Prior Notification for a Permitted Development (Householder)

Development: Notification under extended permitted development rights for a single storey rear extension measuring 4m from beyond the rear wall of the original dwelling house, with maximum height of 4m and eaves height of 2.5m.

Location: 10 Alexander Avenue Angmering BN16 4PQ

BLOCK PLAN AS PROPOSED @ 1 : 200

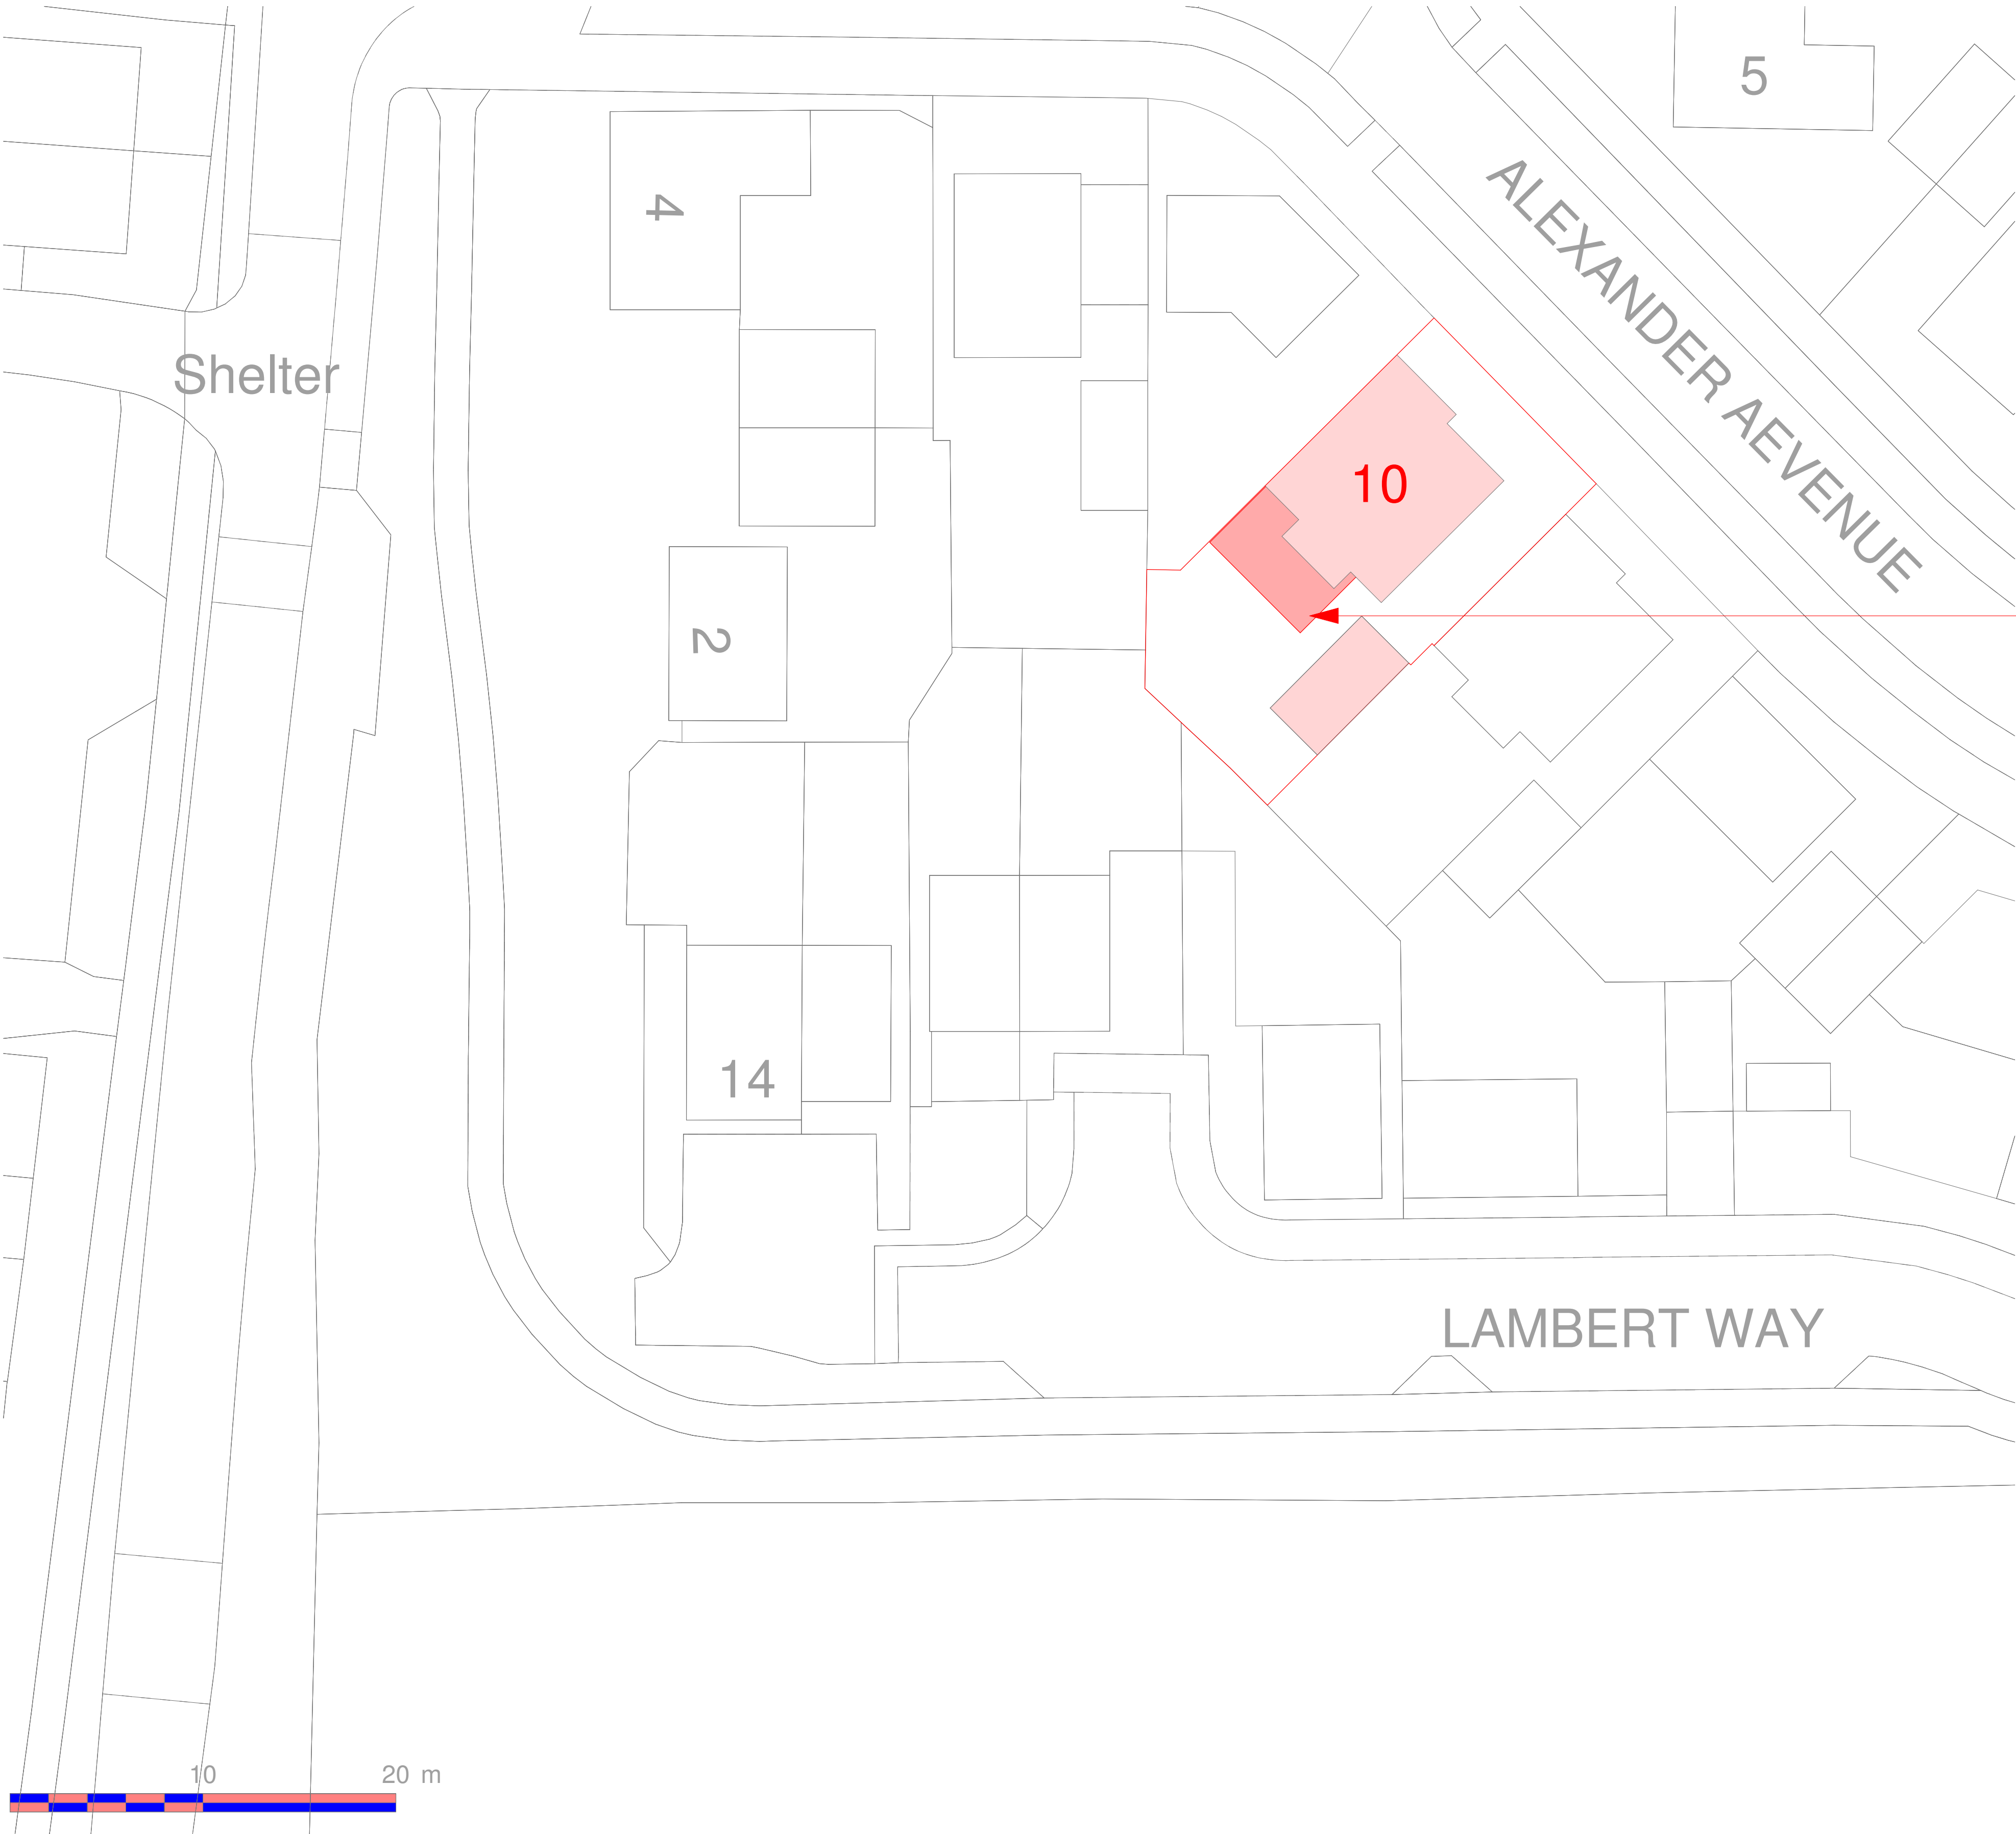
Block Plan

Please amend the Block Plan to clearly show the Proposed extension and resubmit.
